January 17, 2022

Re: Agency Review Comments

We are in receipt of your review letter dated October 21, 2021. Below is a point-by-point response to the unresolved comments prepared in coordination with the (Developer) and Design Team.

**WAHATOYA POINT - TYPICAL SECTION - 5
(PRIVATE DRIVEWAY)**

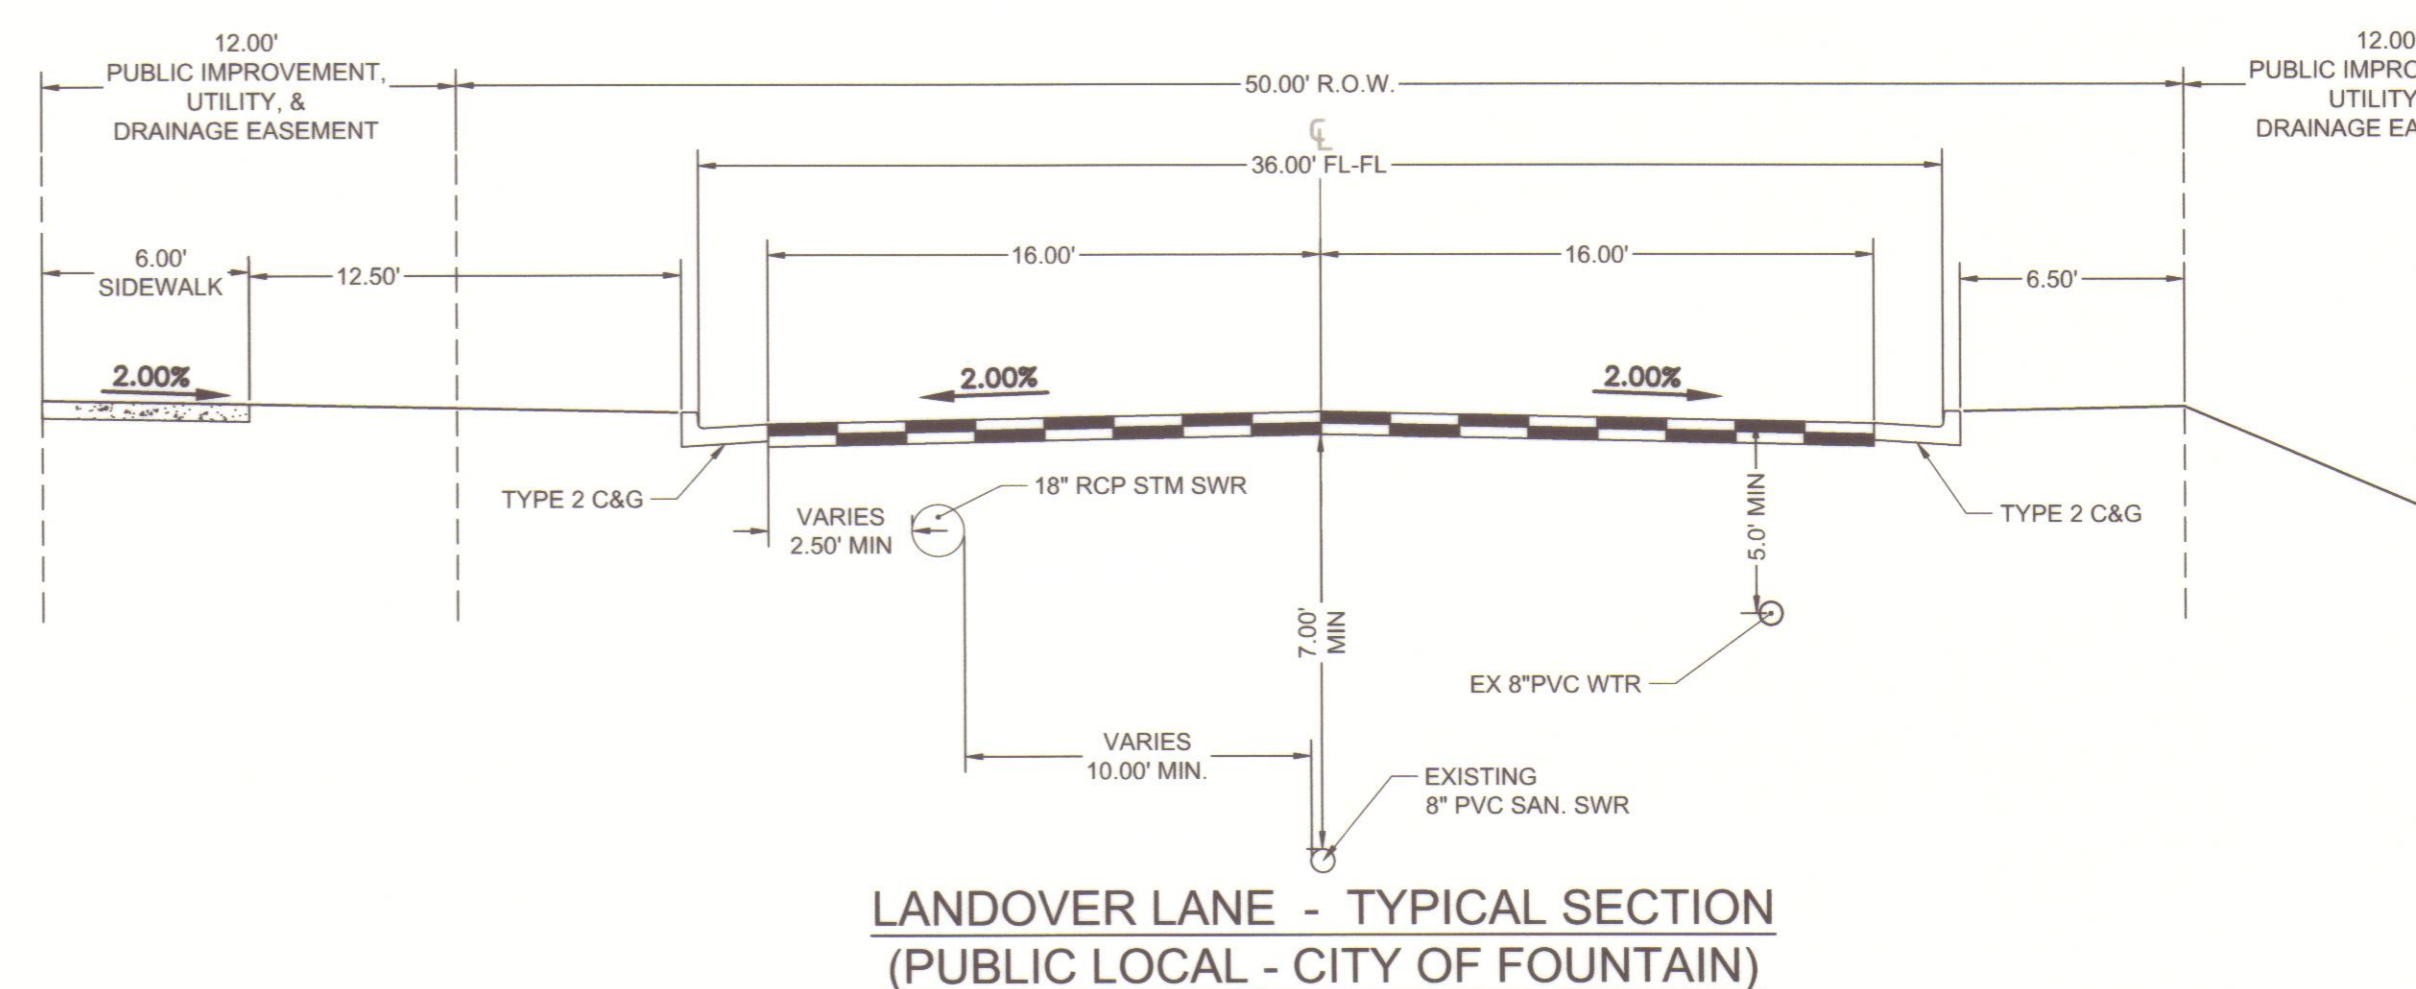
**HR Green Response: Unit numbers added to plan.**
3. It appears at least three street names are needed, provide a list of proposed street names to Justin Annan [jannan@elpasoteller911.org](mailto:jannan@elpasoteller911.org), and Glen West [gwest@elpasotellerp11.org](mailto:gwest@elpasotellerp11.org) with El Paso/Teller County 911 Authority. An email from E-911 showing street names is required for Enumeration approval. Once street names are approved, add to the development plan.

1. Roads depicted in the drawings are currently lacking names

**HR Green Response: Approved street names have been added to the Plans**
4. An amenity center was referenced in the letter of intent. Is this a structure? If this is a building, show location on approved development plan for addressing.

**HR Green Response: Approved private drive names have been added to plans.**

SITE DEVELOPMENT PLAN
ELEVATIONS - CLUBHOUSE

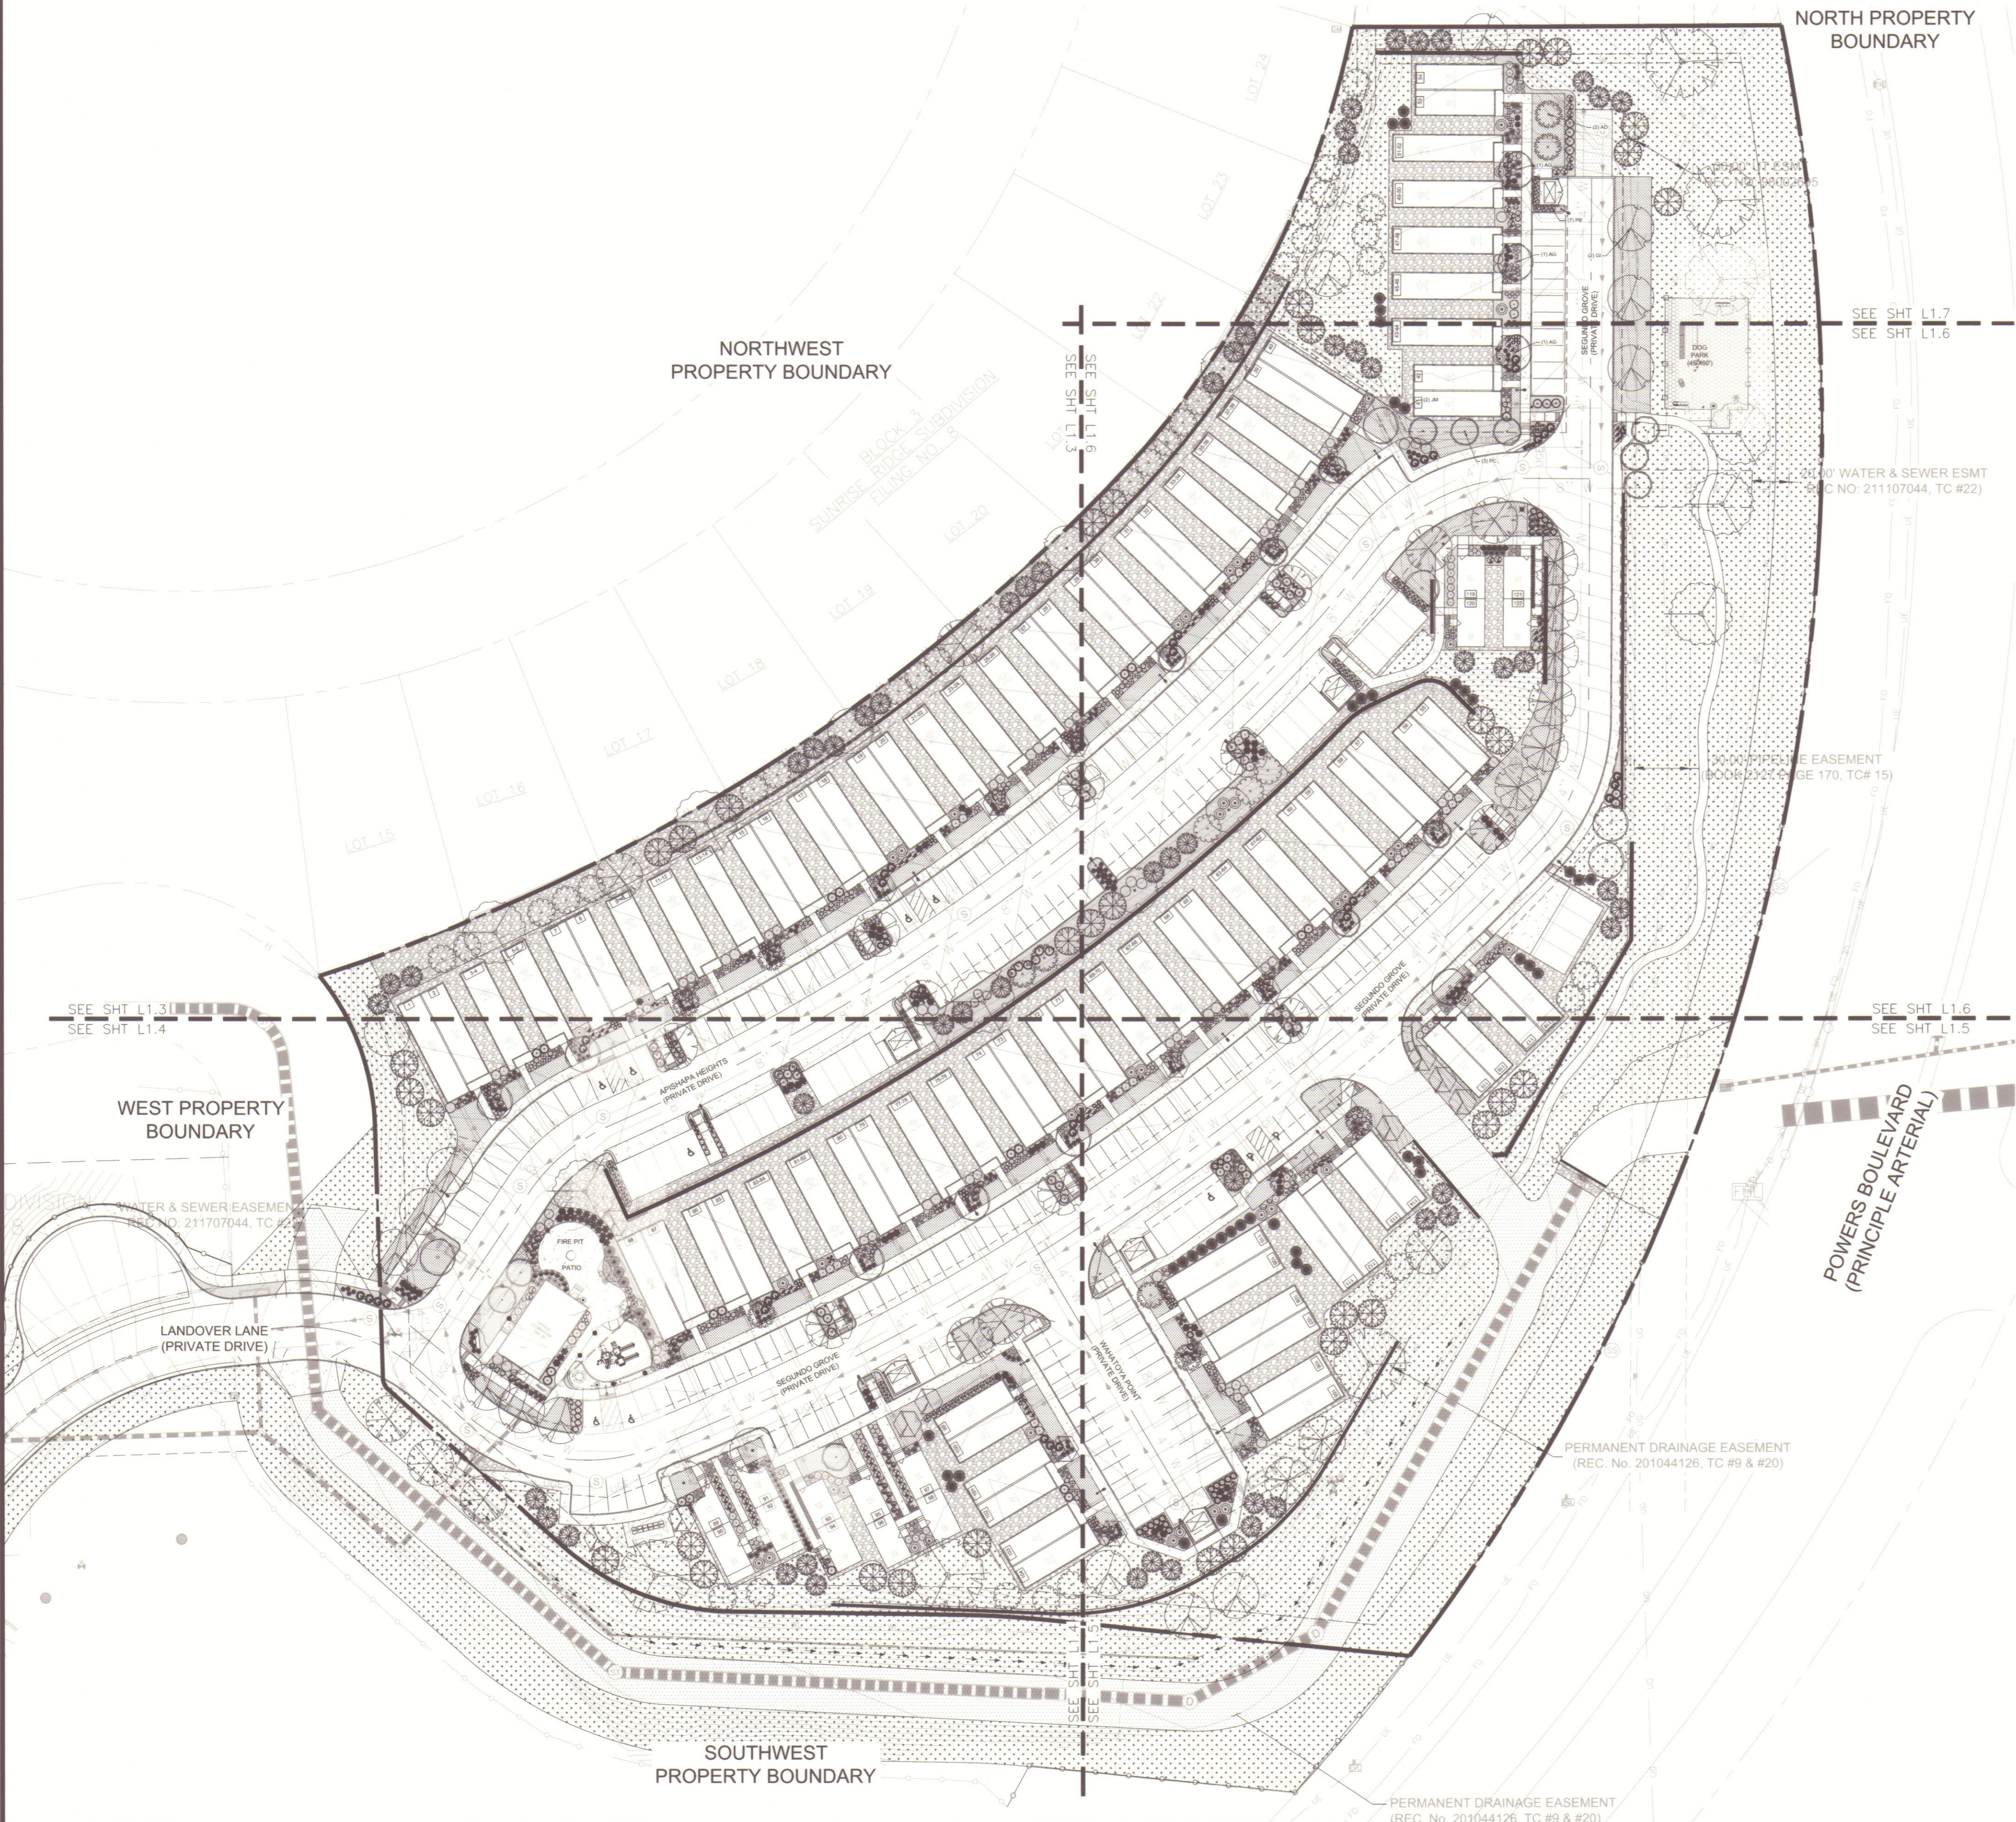
6. Provide the details for the residential club house w/ pool on a sheet; this is in-lieu of a site development plan. Verify all dimensions and SF is depicted on detail and any parking, ADA ramps sidewalks, patio areas etc

**HR Green Response: Additional detail has been provided for the residential club house within the final landscaping plans and Preliminary/PUD Plan. Please note there is no pool proposed.**
